Application No: AB/19/22/HH
Site Address: 39 Priory Road Arundel BN18 9ET
Description of works: Proposed side extension, loft conversion, changes to external finishes, together with internal alterations and all associated drainage works

Thank you for your internet representation made on 1st April 2022 which has been recorded as an objection with the comments as follows:

Elevations and section as proposed

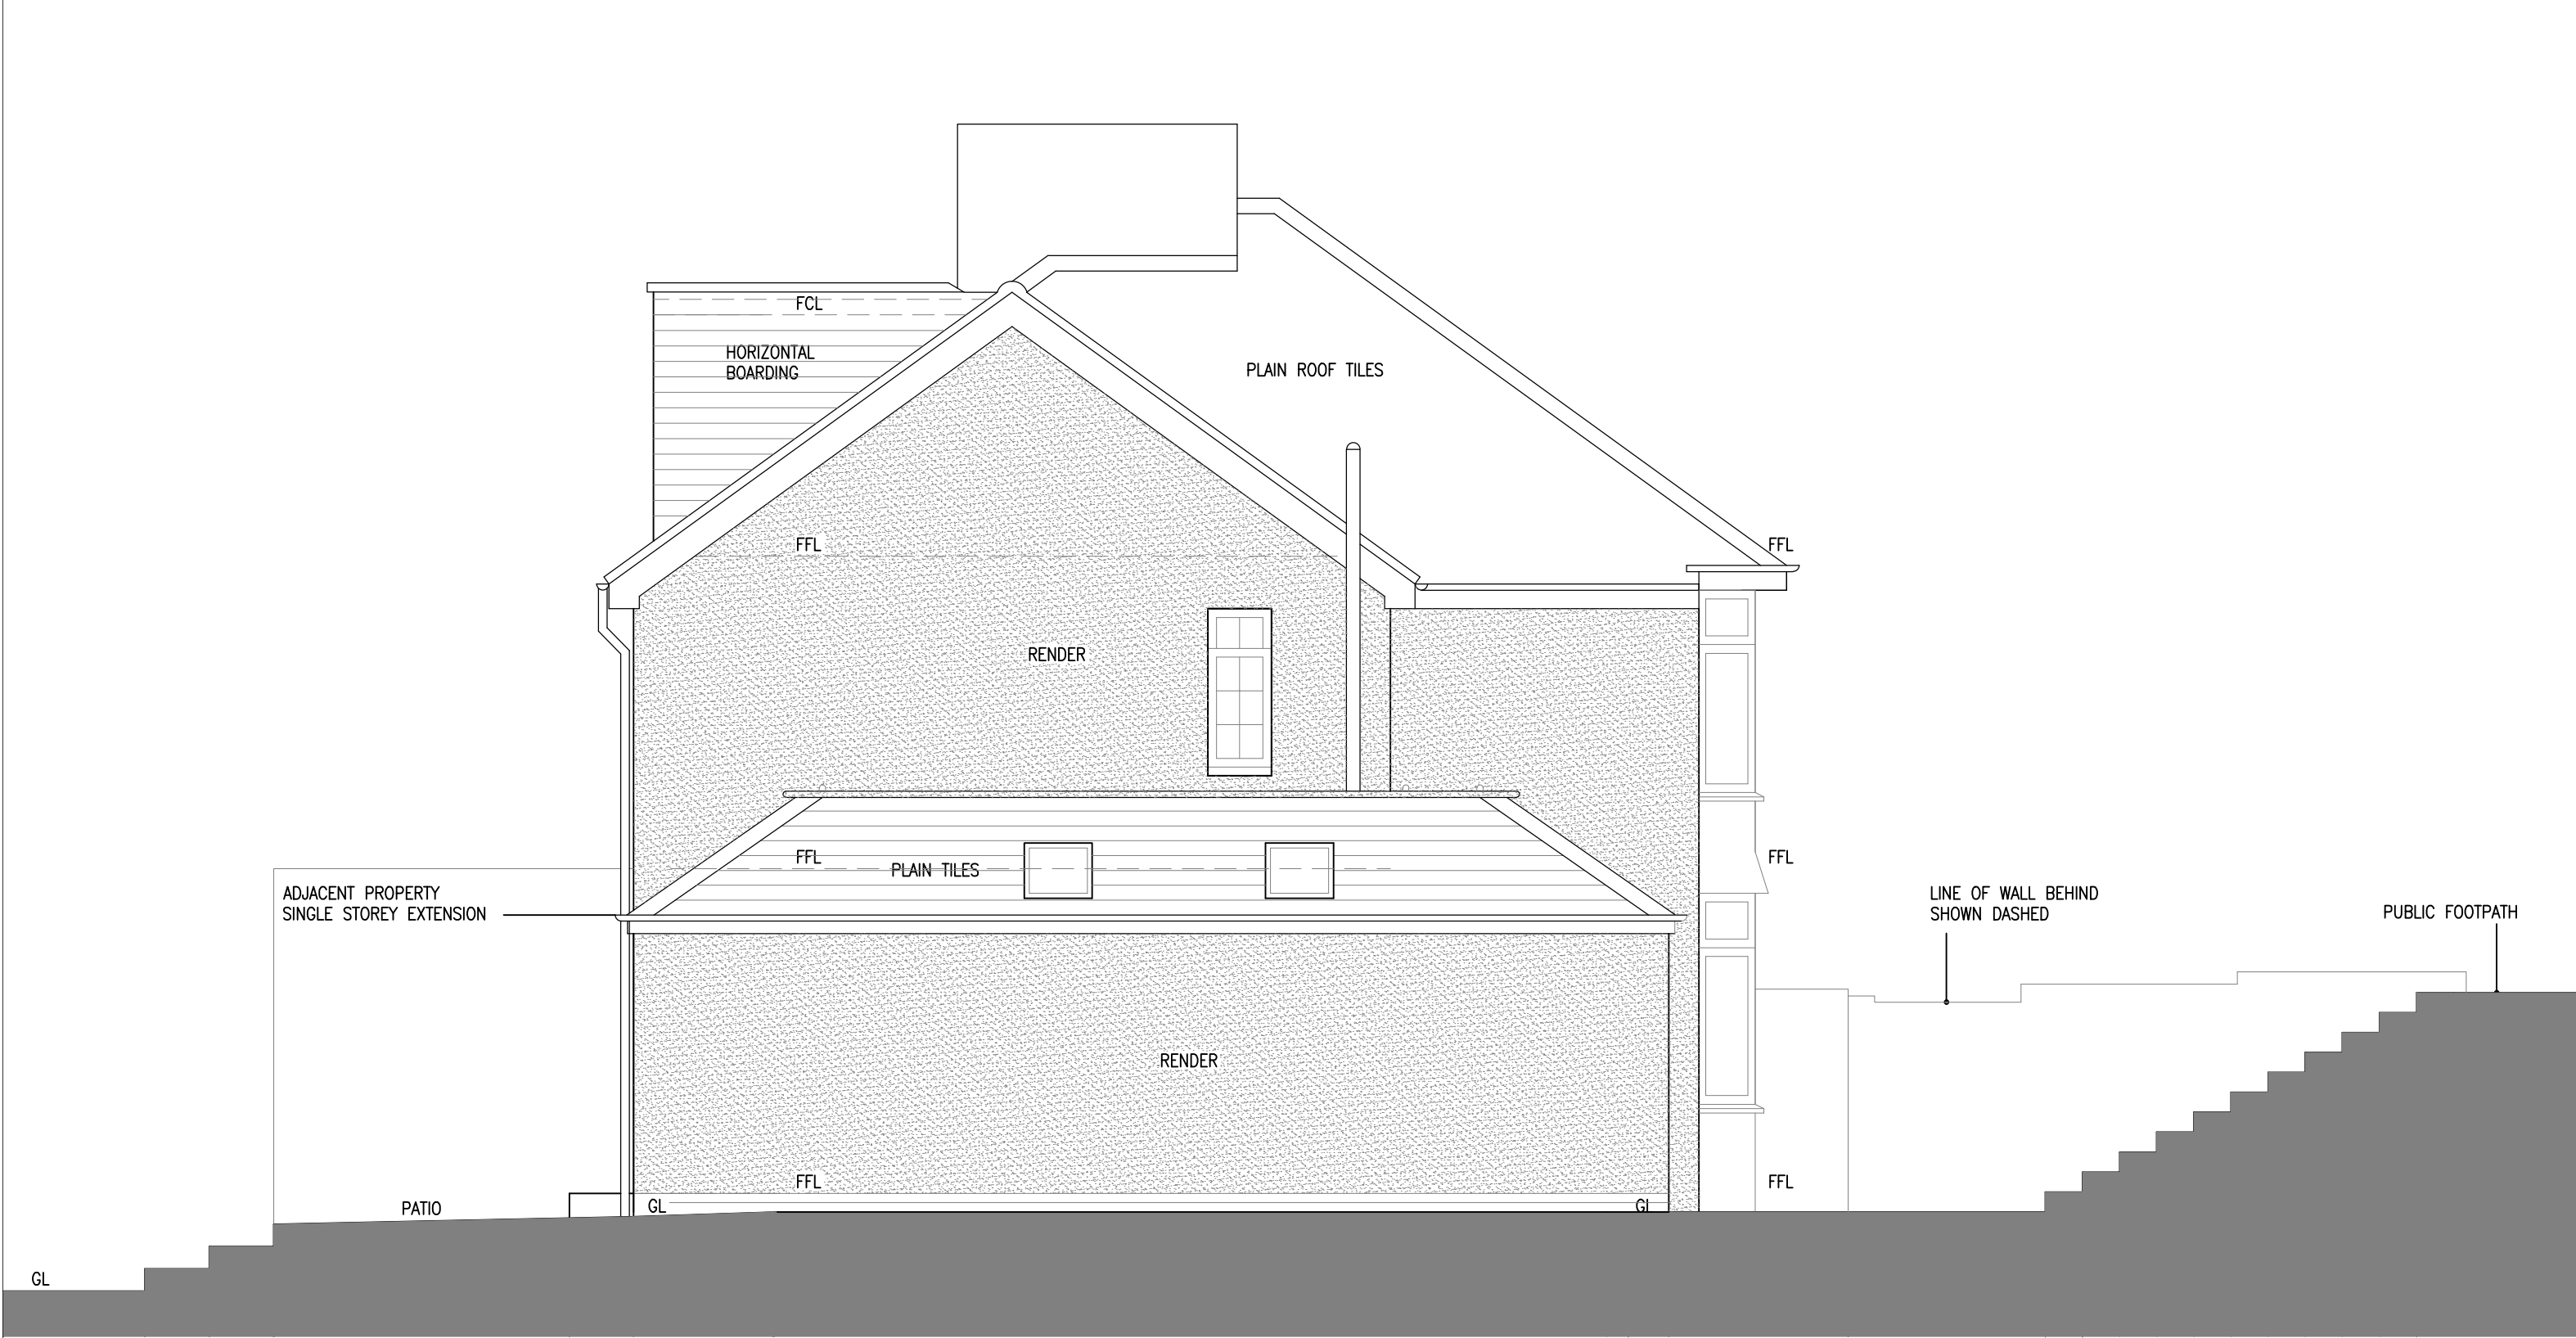
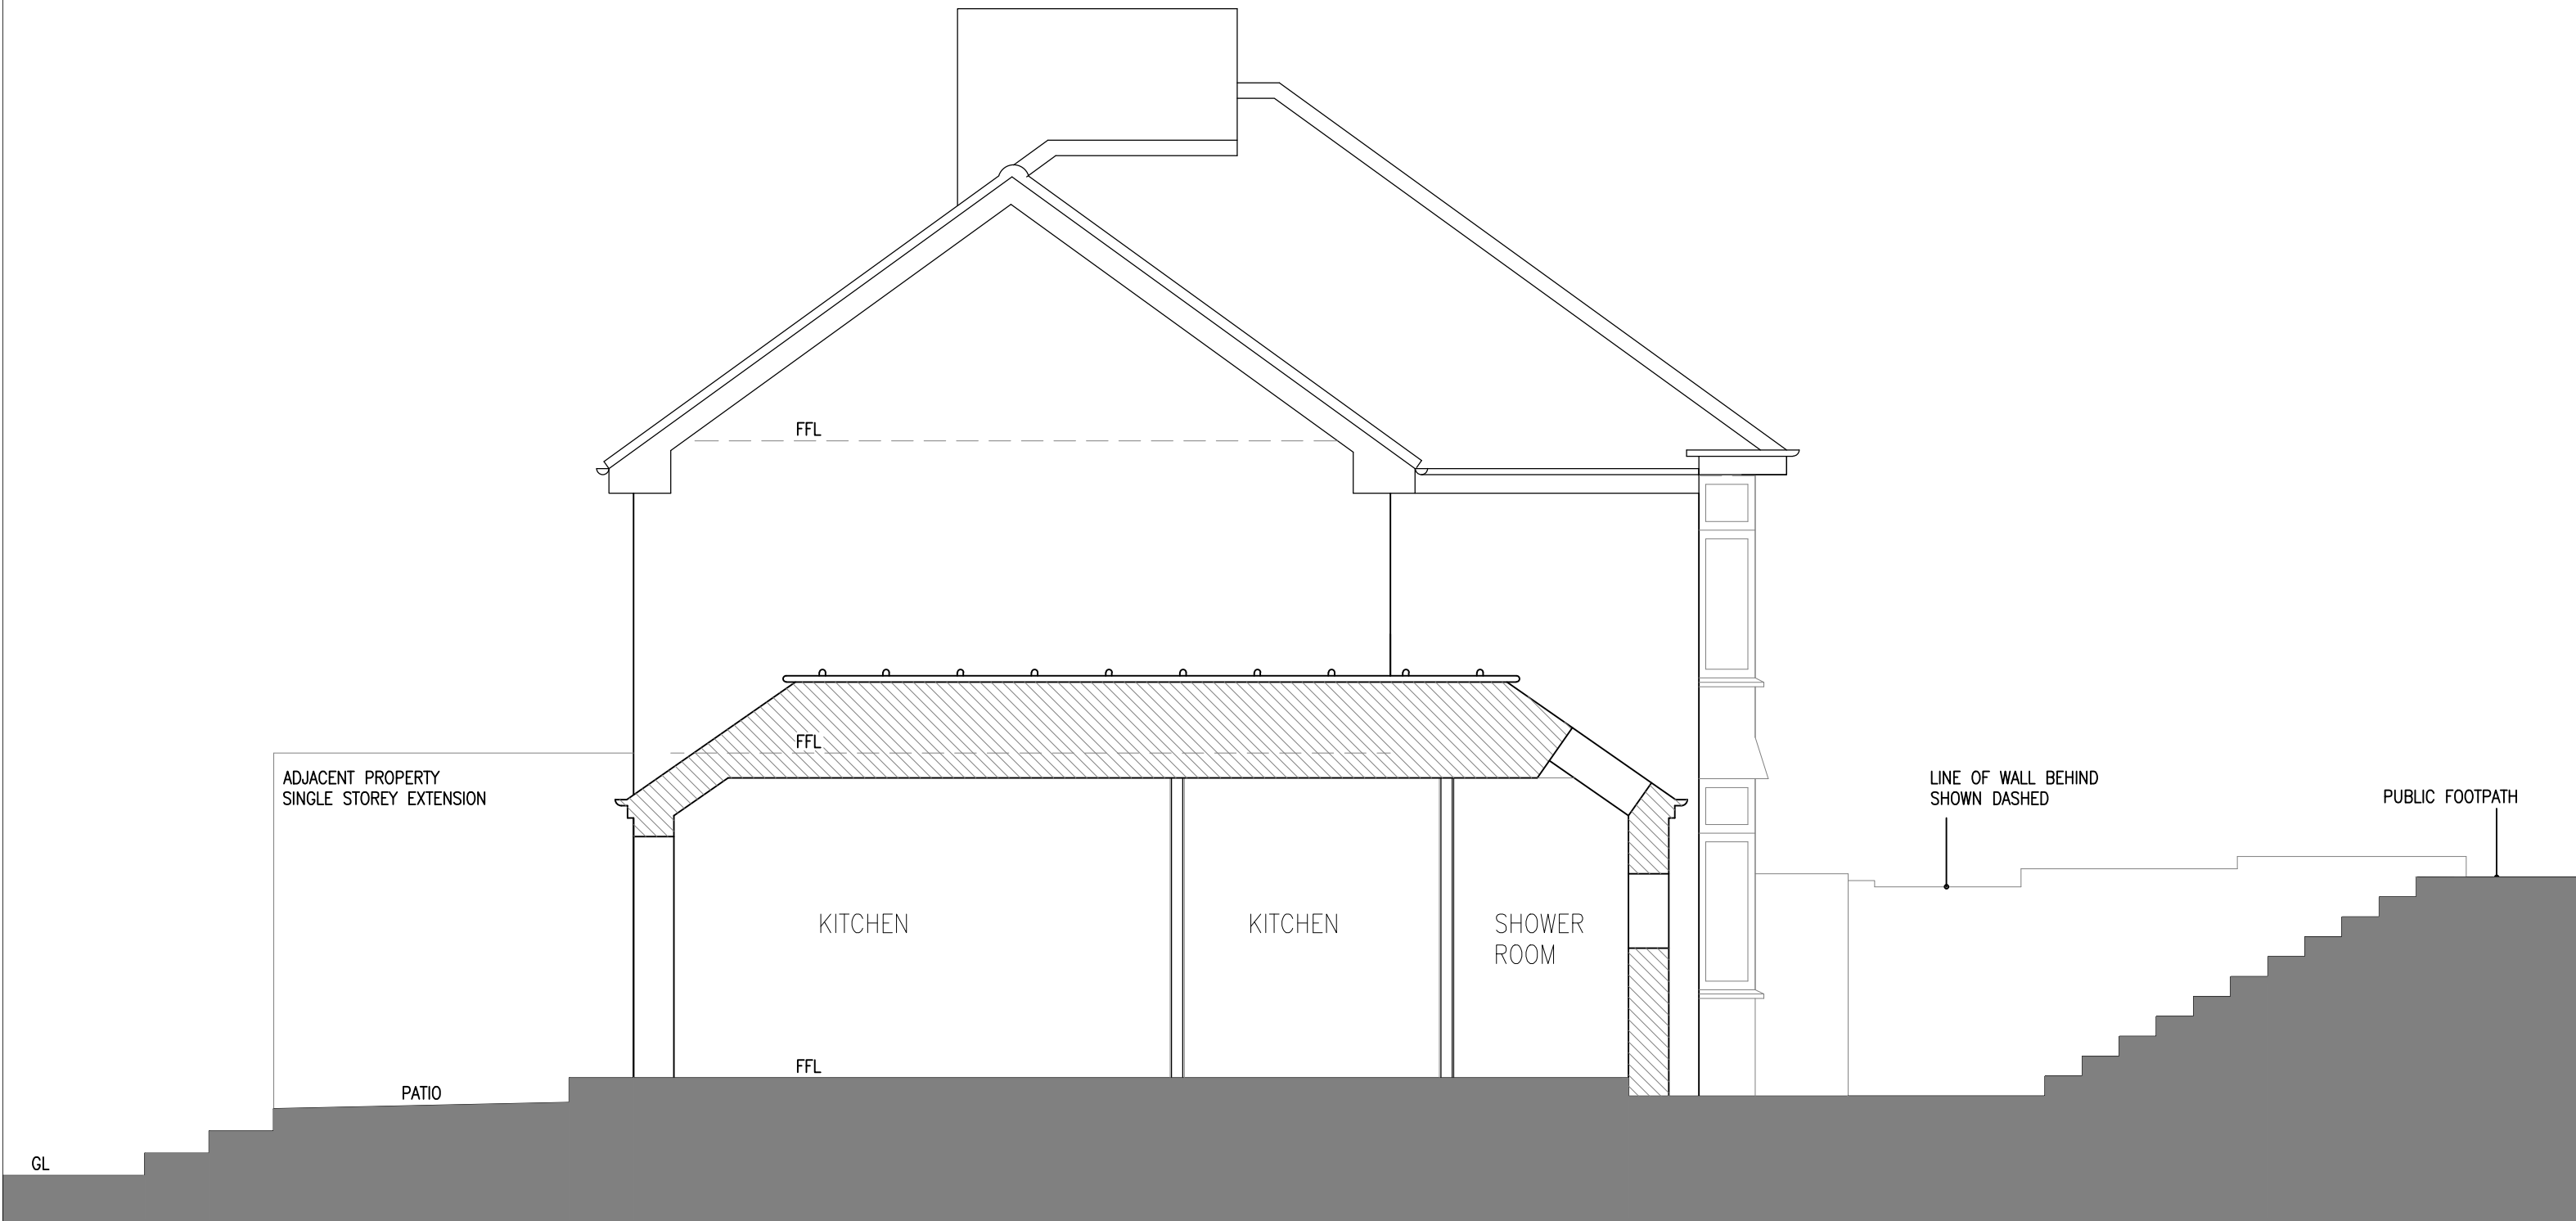
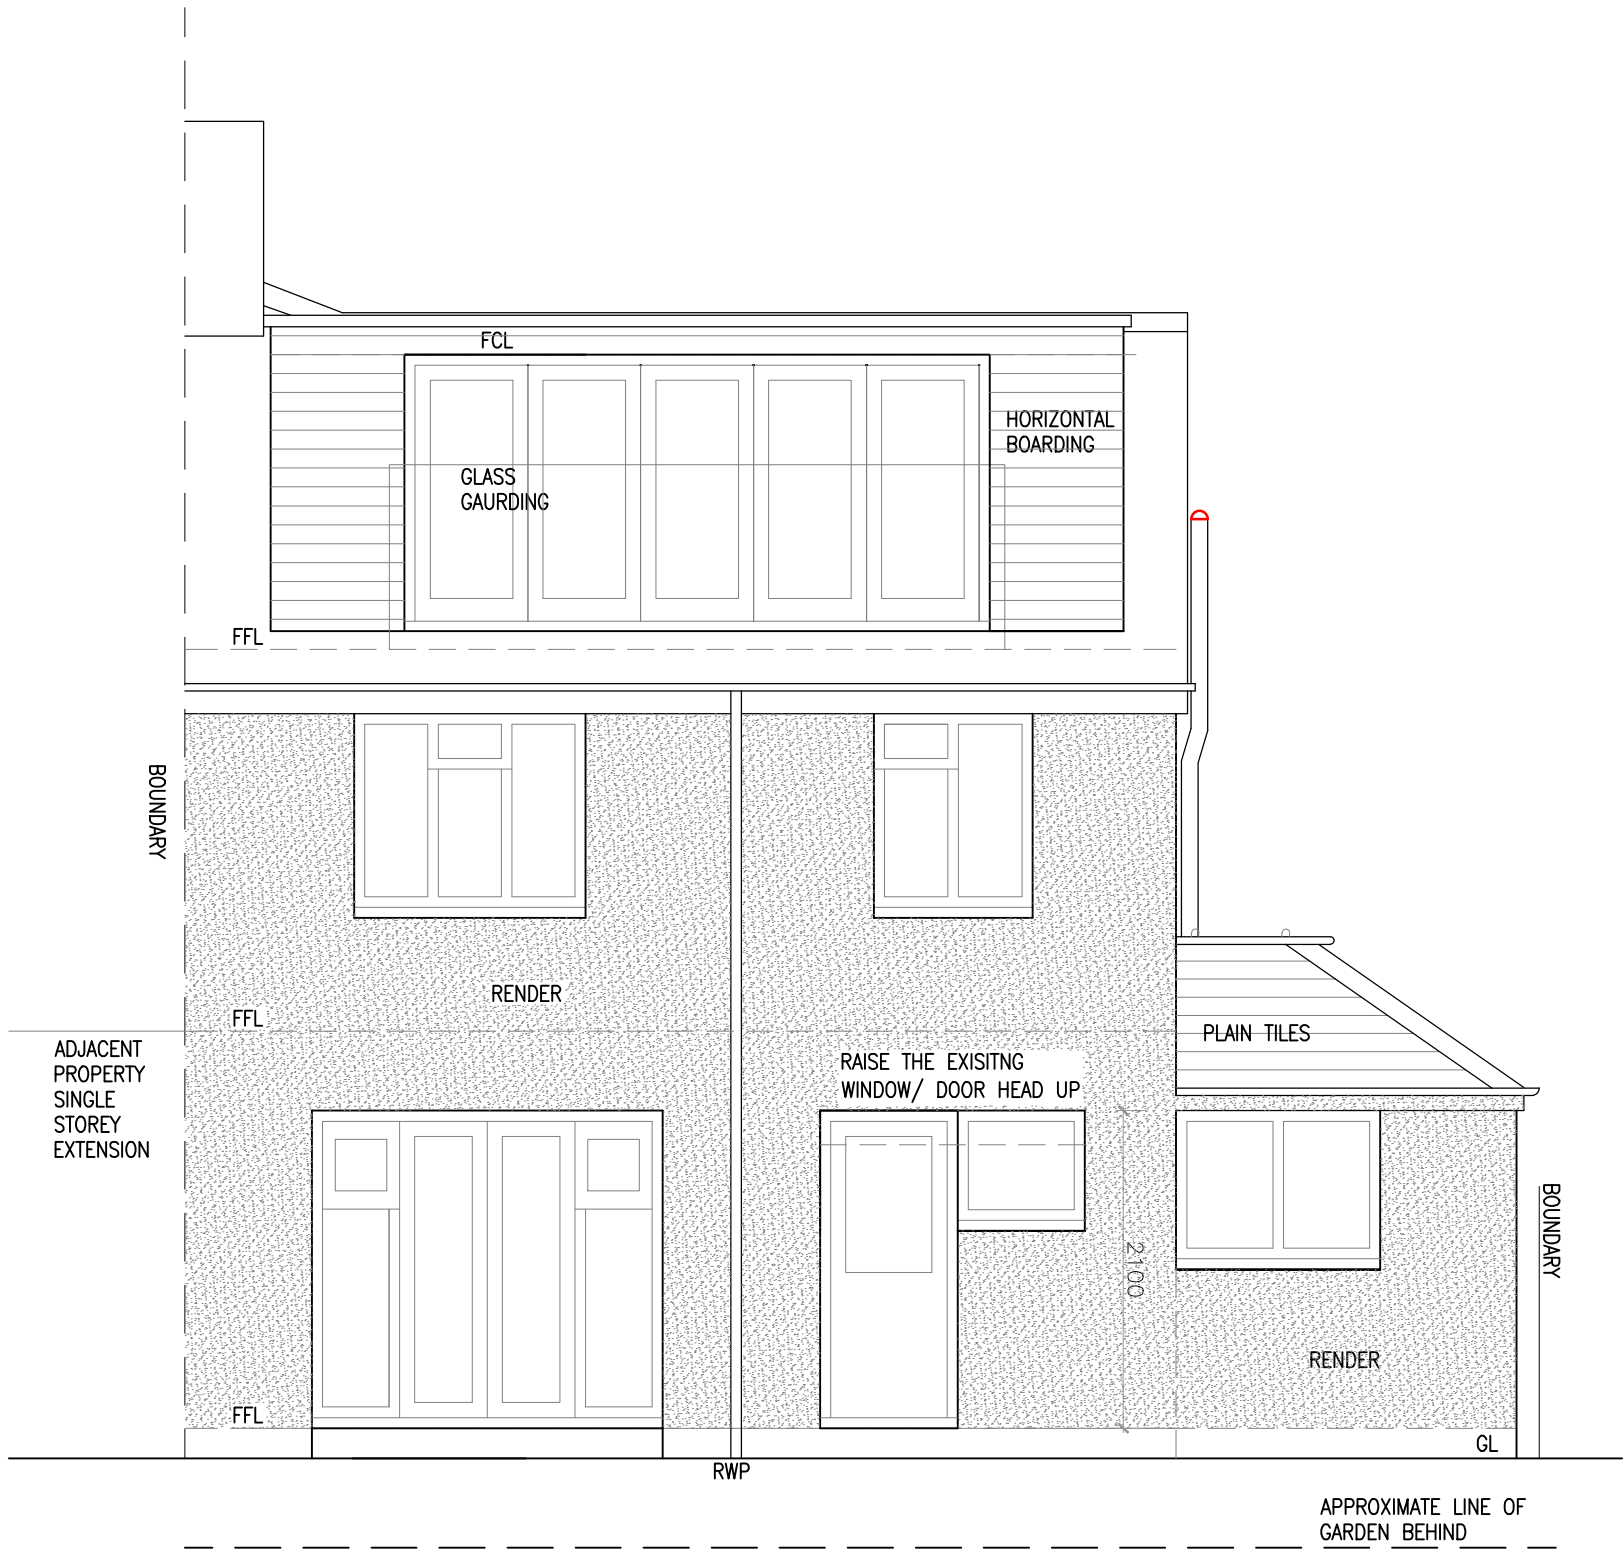
The Committee objected to this Application on the basis that the render being used is unsuitable for the street scene. The Committee referenced SP1 of the Local Plan - All development proposals should reflect the characteristics of the site and local area in their character, materials, finish and architectural details.
